CITY OF ALBUQUERQUE
PLANNING DEPARTMENT
June 4, 2014
DRB Comments

PROJECT # 1002962

APPLICATION # 14-70186

RE: Tract 1, The Trails Unit 2

SKETCH PLAT FOR
TRACT 1
at the TRAILS UNIT 2
BEING A REPLAT OF
TRACTS 1
at the TRAILS UNIT 2 &
UNPLATTED LANDS OF
MANUEL R PILI

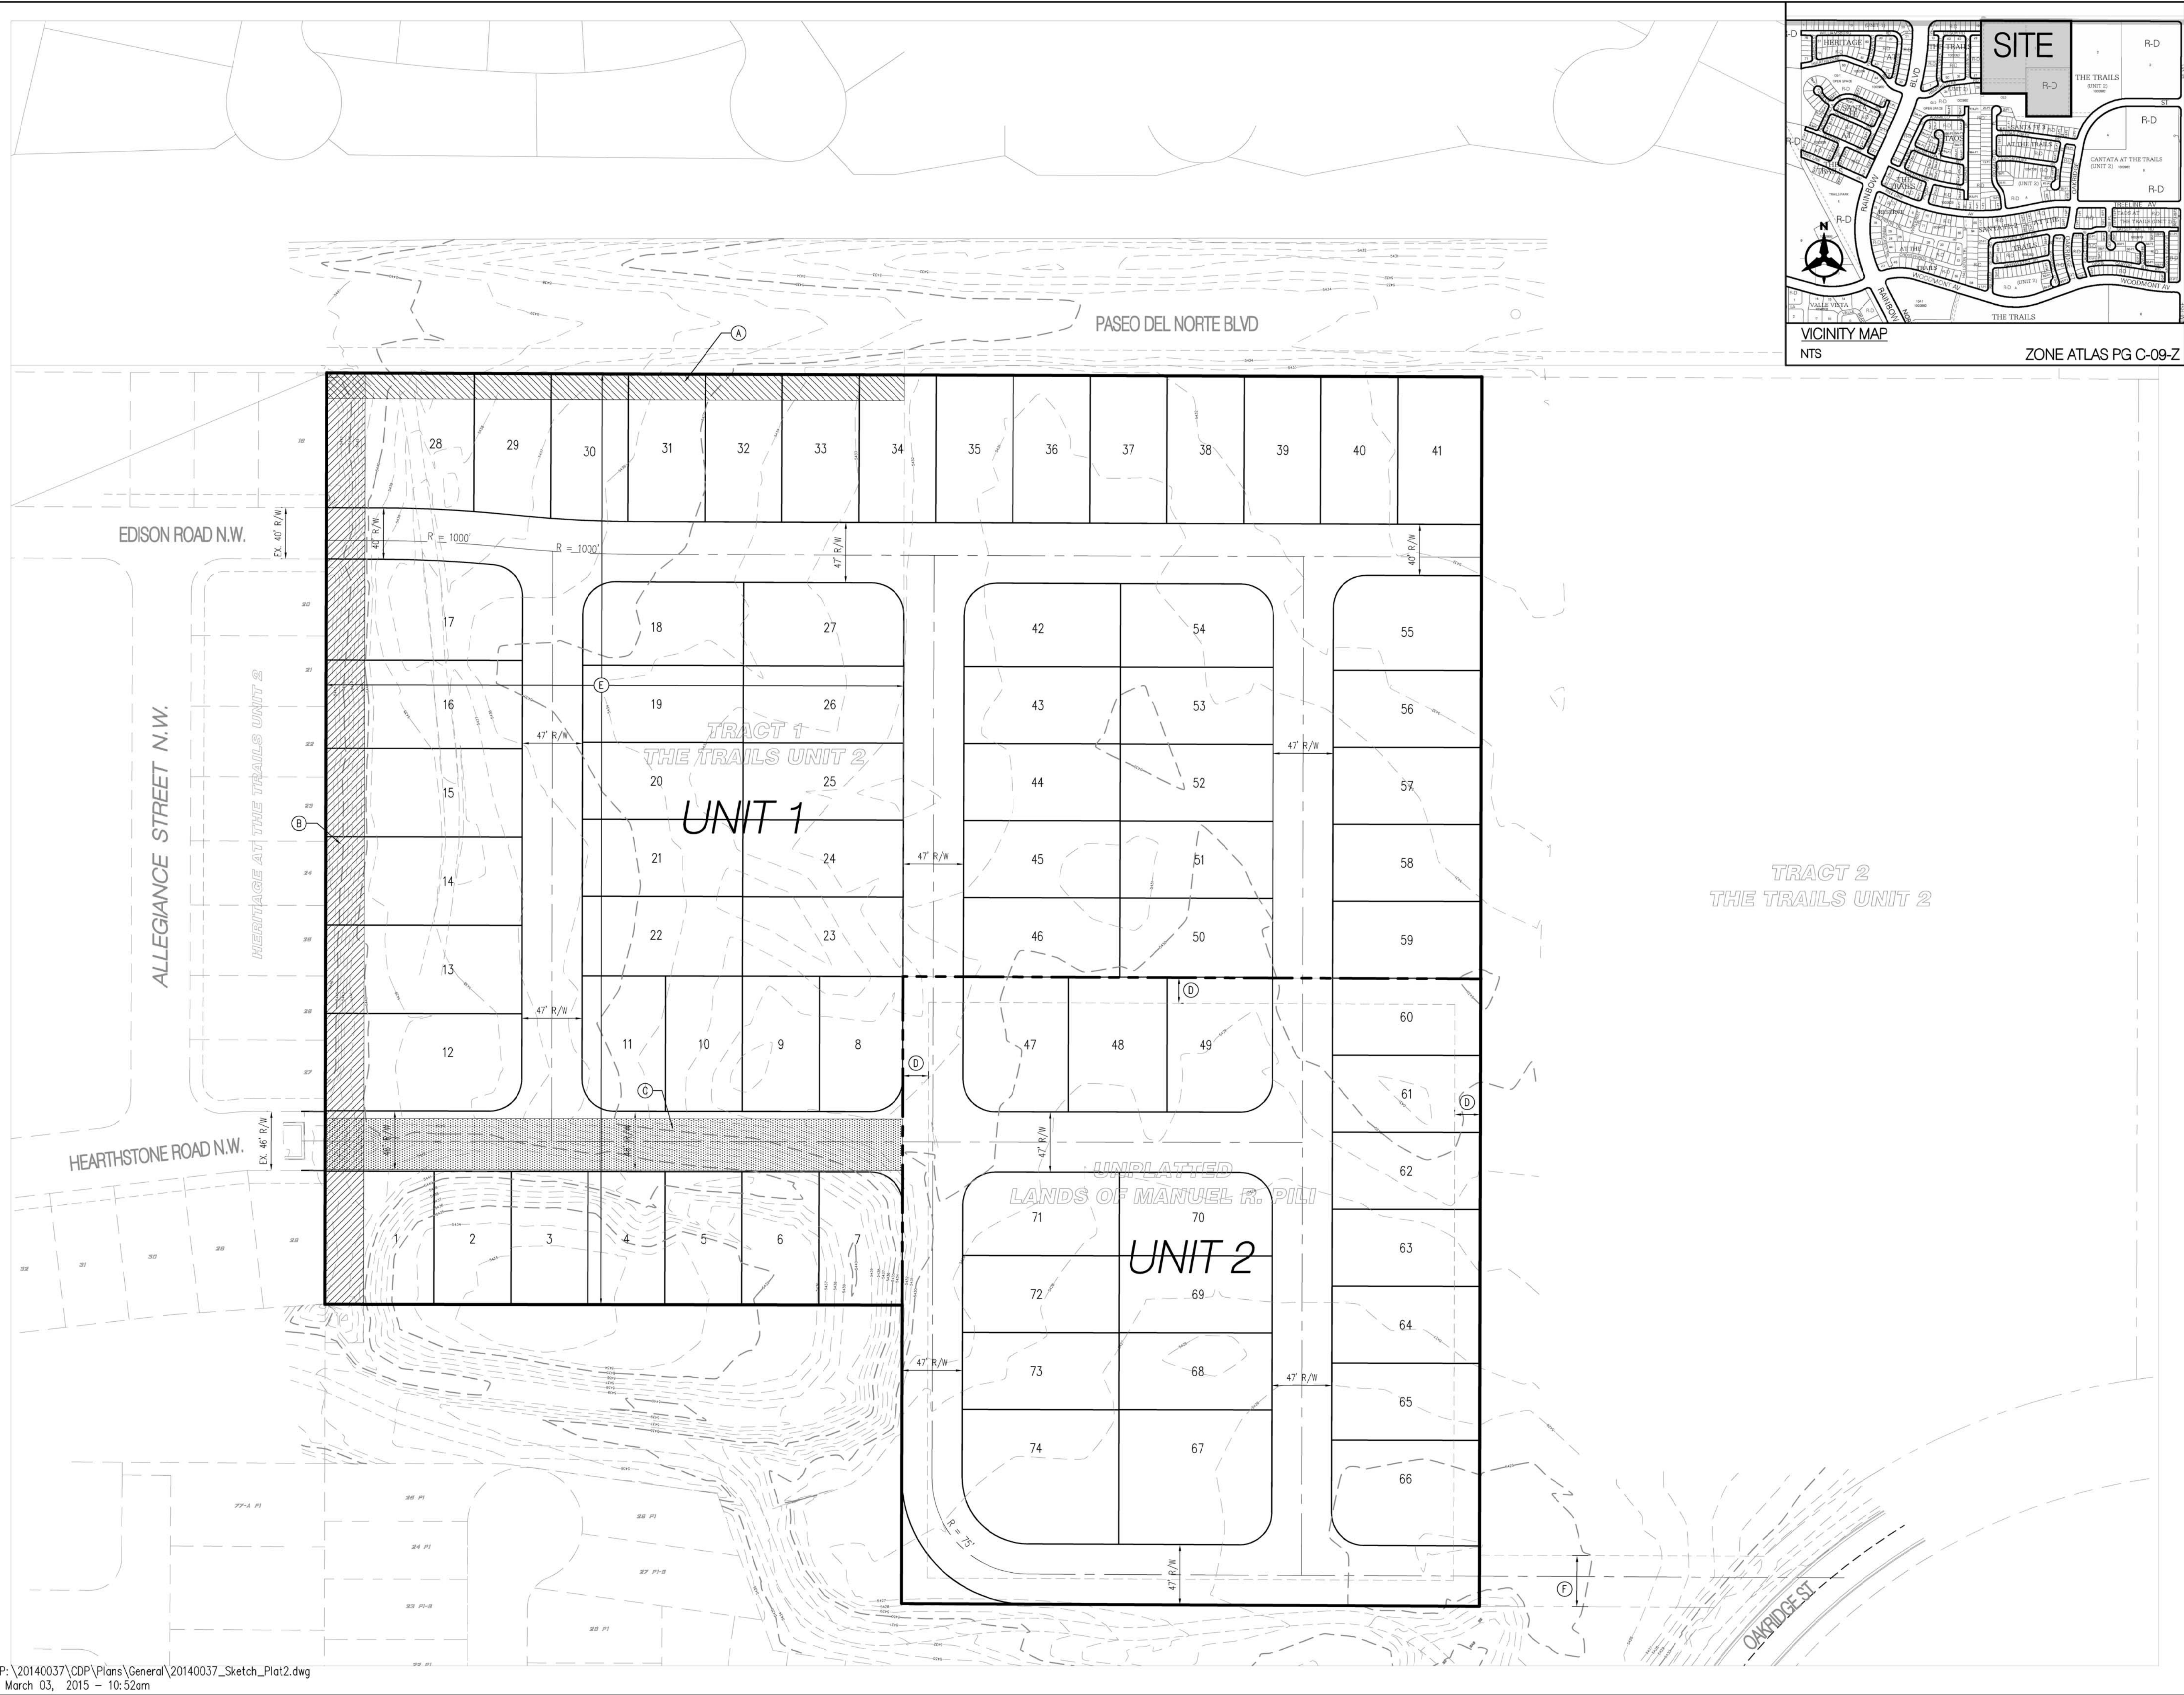
Proposed Unit 1 will require completion of access to Oakridge St, and a turnaround will be needed for the easternmost N/S street to conform with access criteria of the DPM.

Refer to the Volcano Trails Sector Plan for design requirements; site plan will need to specifically address the Open Space requirements of the R-D zone.
